Maine Medical Center Bramhall Campus Environmental Graphics & Wayfinding Program

Site Submission

11.27.18

Response to City Comments and Recommendations

Option 4: Blade Site Line Study at Entry

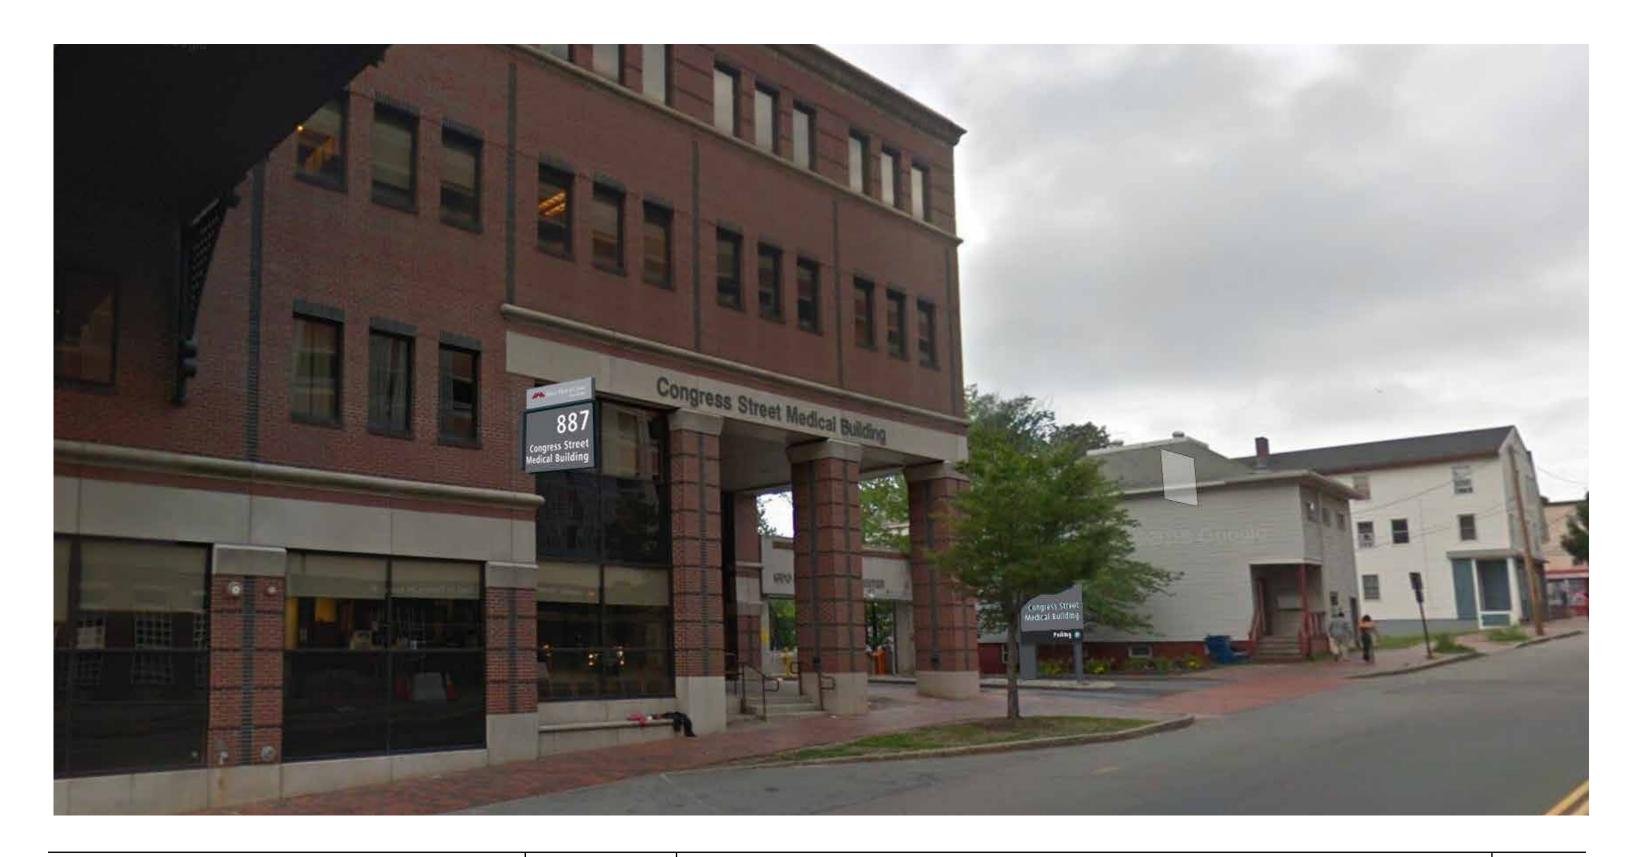
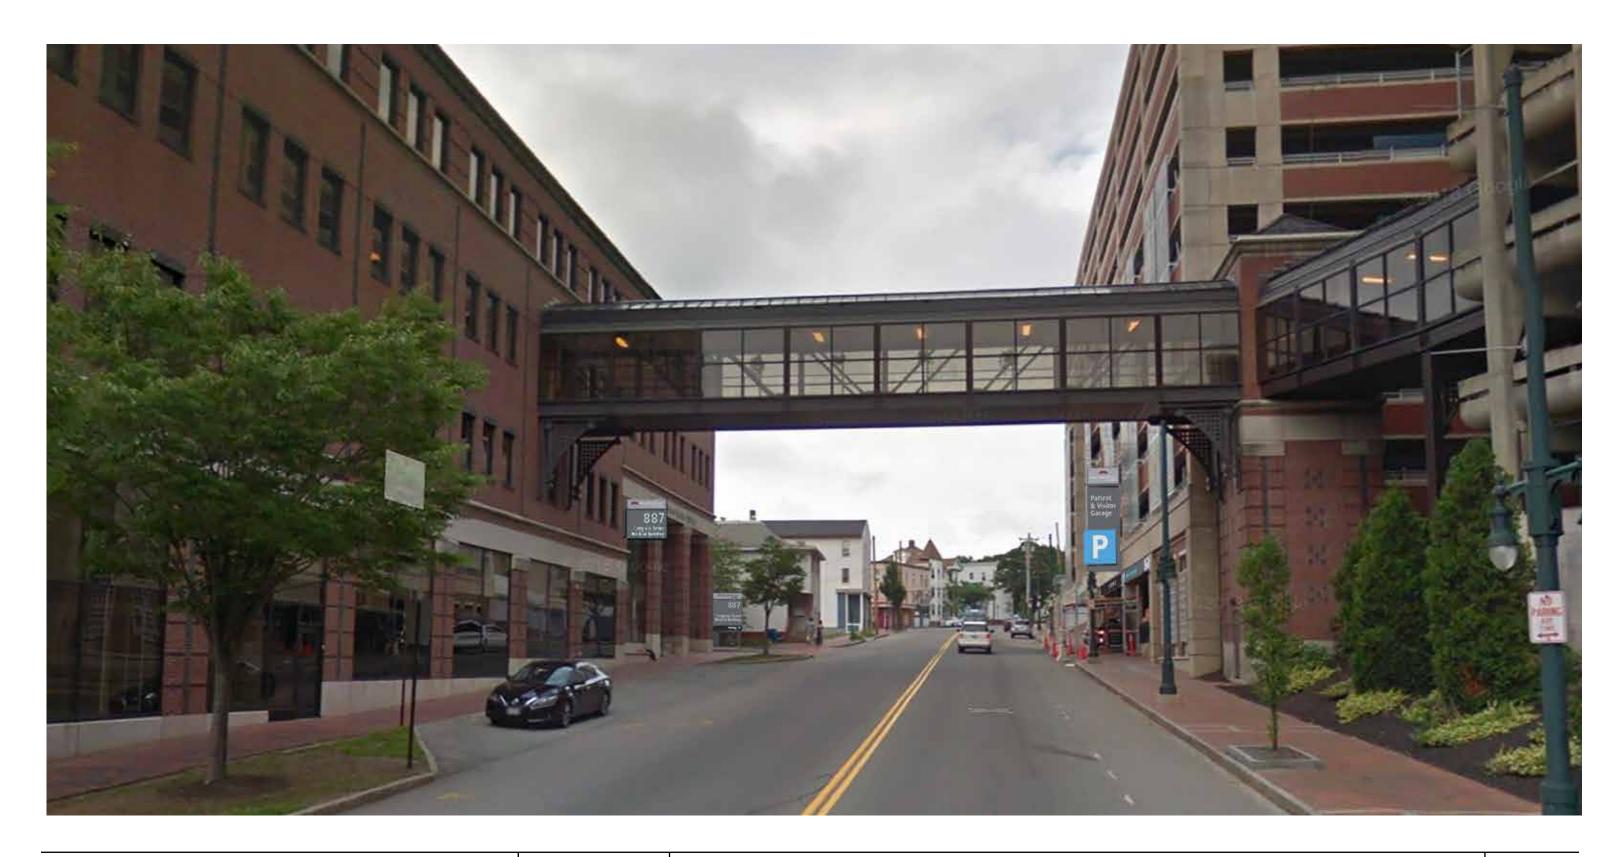
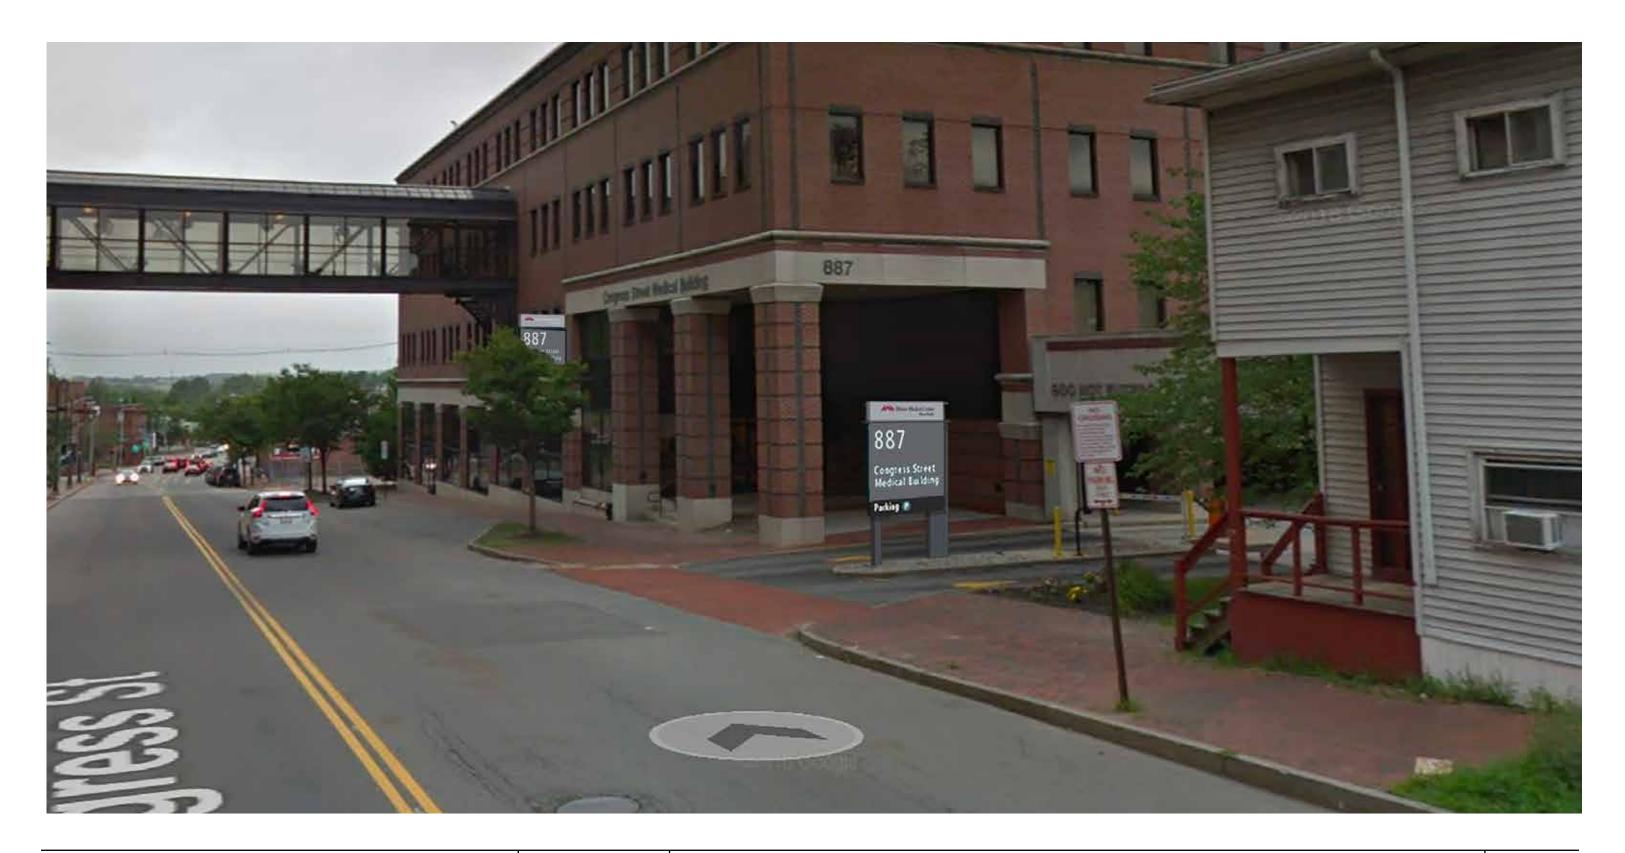
- No signs will be permitted on properties not owned by MMC (e.g. 1b)
- There are concerns about sight line obstructions on several of the signs, including ST.1a, CS.2 and EG.1a.
- Please provide a sight line analysis (Included)
- There are concerns about the size of the signs in general. Could those proposed as 11' in height be brought to a more pedestrian scale (e.g 8'?) There are particular concerns about the size of 4a, which is replacing a much smaller sign and 6a. Both of these signs should be brought to a pedestrian scale
- Eliminate one of the signs marked 5.b and reduce the size of the remaining to the scale of the existing sign
- Please indicate dimensions of CS.1 and method of illumination. At first blush, this sign appears out of scale.
- The layout of EG.1a is inconsistent with the other signs of similar purpose (e.g.ST.3a). Is there a reason for this?

We appreciate the comments and direction offered by the City and have considered them. We believe the designs put forth the best approach for patients and families visiting MMC. Our overall design approach includes:

- Using existing sign foundations and locations (where possible)
- A 15% reduction in sign sizes from the current design
- Reduction in overall quantity of signs from the current system
- Better alignment with the MMC brand and architectural enhancements
